**WEST SUSSEX COUNTY COUNCIL
STRATEGIC PLANNING CONSULTATION**

SUBJECT: A/131/15 – Application for approval of Reserved Matters following Outline Approval of Hybrid Application A/125/13 for the development of the site to provide up to 3,365sqm A1 retail use (including parking). Reserved matters consent is being sought for Appearance, Landscaping, Layout and Scale

Address: Land south of A259 and west of Mill Lane, Rustington Parish of Angmering

Drawing Title
Proposed Plan

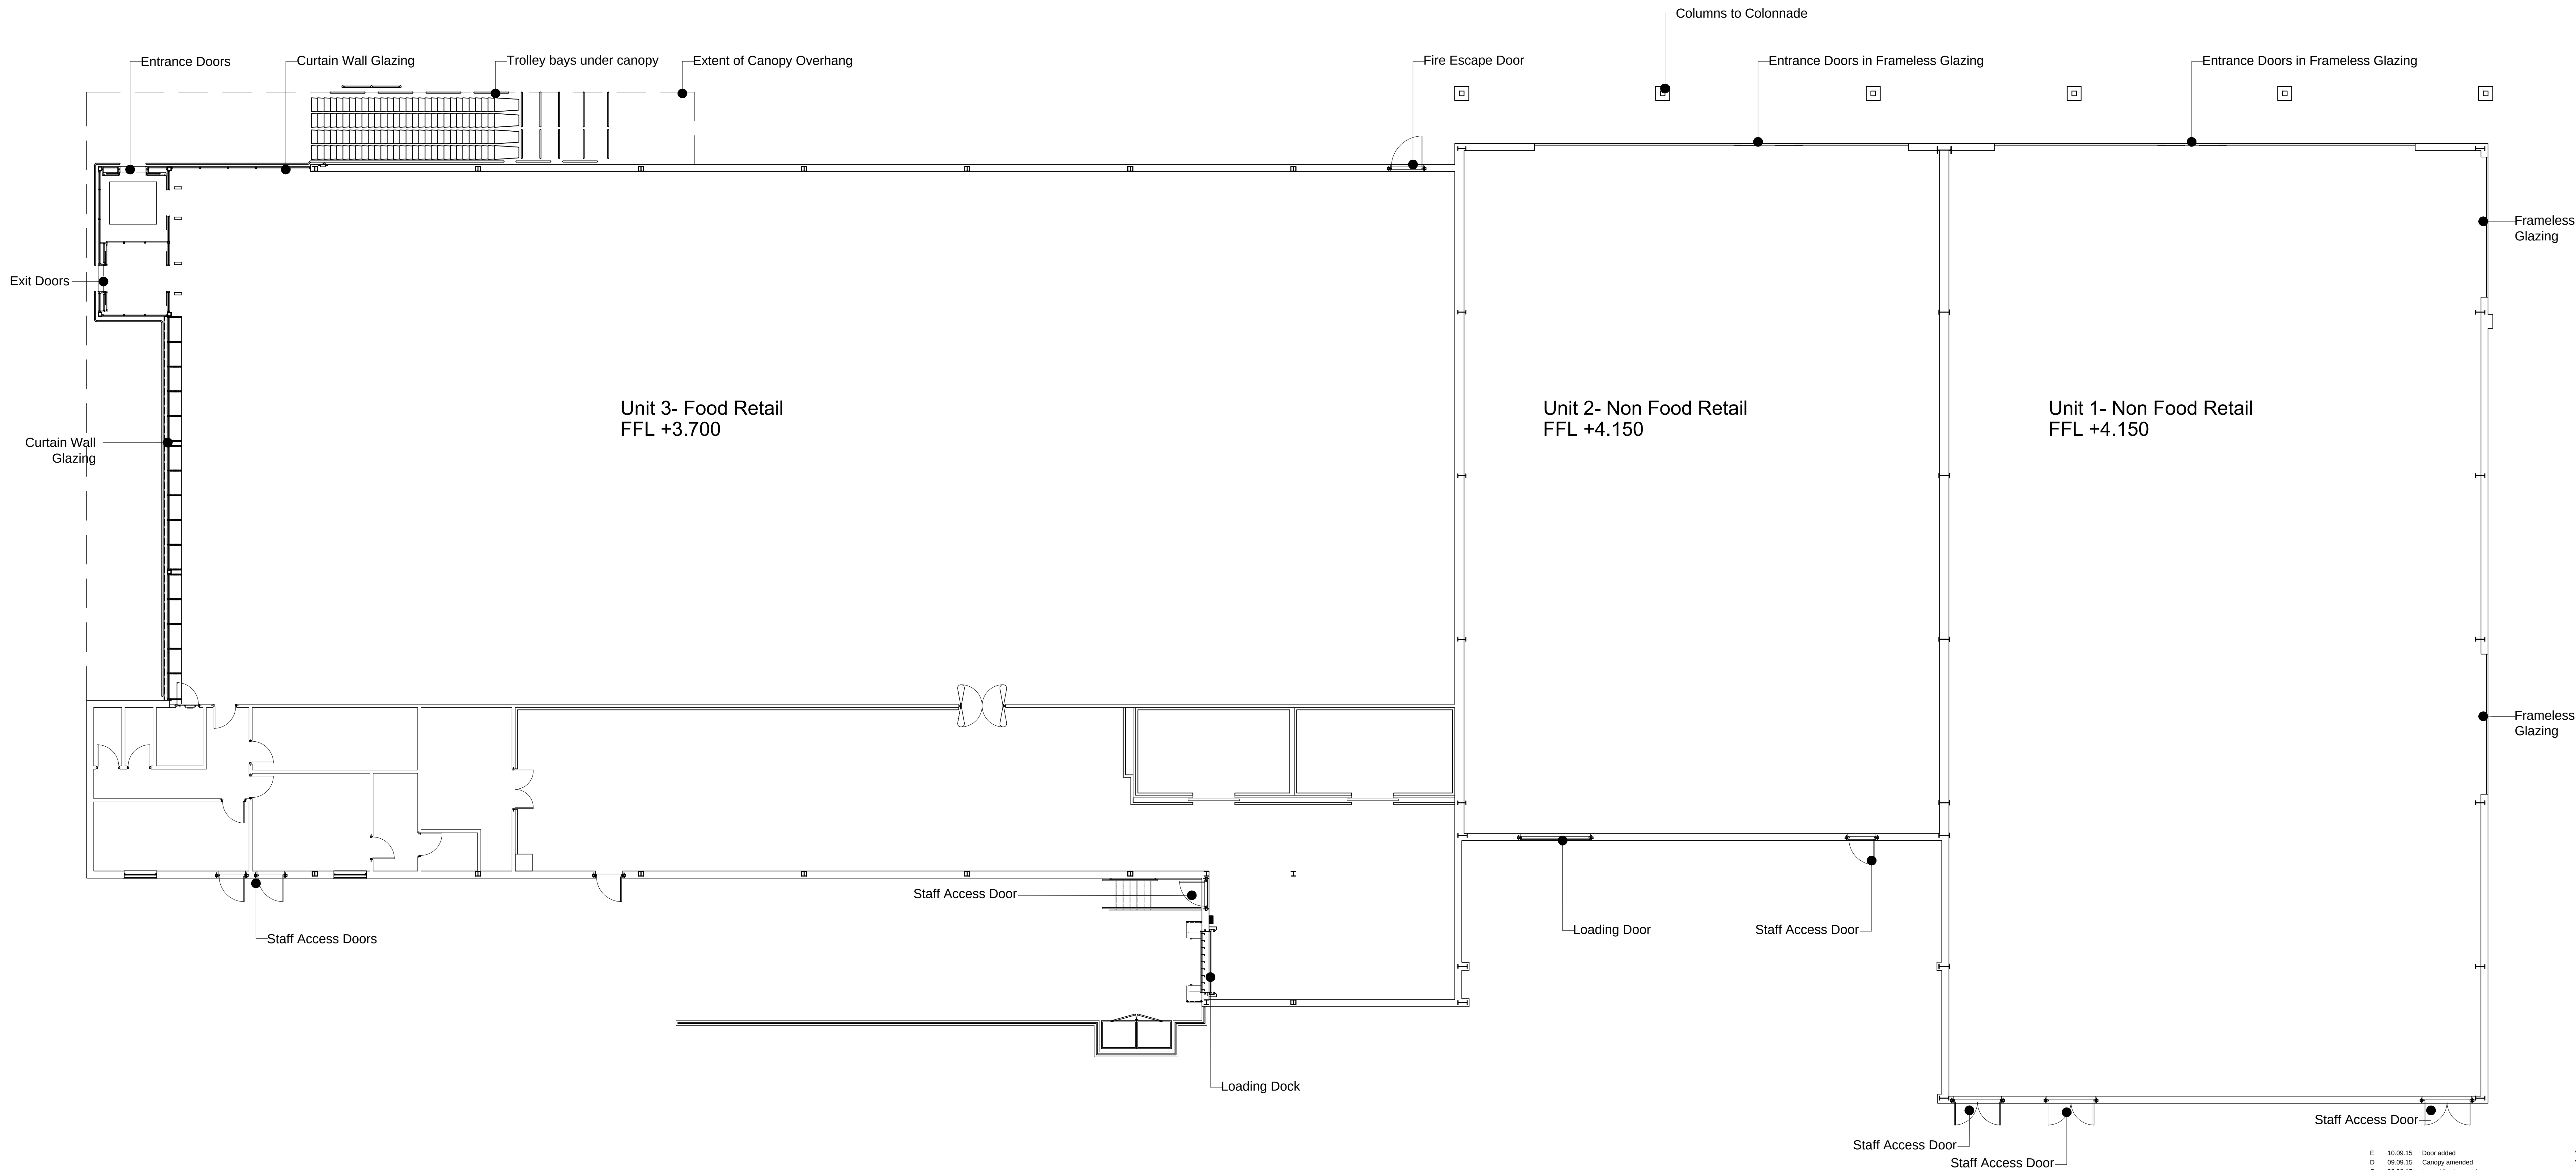
Referring to drawing number 6165-003-Rev1, 224 car parking spaces are proposed, including 16 disabled spaces and 14 family spaces. Parking surrounds the west, north and eastern aspects of the site, and generally follows the line of the building footprint.

No car park tracking diagrams or parking bay/aisle width dimensions have been provided. A swept-path analysis should be undertaken of a number of parking bays, as a number would appear to be difficult to access, including those in the far top left corner of the site plan. Parking bay geometries should also be provided.

West Sussex County Council guidance (2003) states a required provision of 1 cycle parking space per 100sqm for staff, and 1 cycle parking space per 100sqm for visitors. This would equate to 60 spaces in total (30 staff, 30 visitors). Currently, only 28 spaces are proposed (8 staff, 20 visitors). Further provision should be provided, and staff cycle parking should be indicated on the site layout.

No provision has been made for motorcycle parking – this should be arranged in accordance with WSCC guidance (2003).

It is assumed that the aisle width of the internal road layout measures at least 6m in width; this should be clarified. The Applicant has responded to previous comments raised by the LHA relating to the location of pedestrian crossings; these now appear to be located suitably. It would be beneficial to include one further crossing point to the eastern edge of the buildings from the north. This would further encourage low speeds, and provide pedestrians from the north east of the car park with a suitable route along the desire line to the retail units.

It is important to note that a staggered gate or similar should be provided at the end of the cycle route. This will slow down cyclists from the cycle path before the pedestrian crossing so that conflict with vehicles is less likely to occur. It will also restrict cars from using this route.

Servicing (deliveries, waste collection etc.) is proposed to take place to the rear of the site. A separate access road is proposed, and whilst geometries have not been provided, this road appears wide enough to

accommodate two large articulated vehicles to freely pass. A turning head is located in this area also, however tracking by the largest vehicle to use the turning head should be undertaken to ensure that this manoeuvre can be successfully undertaken.
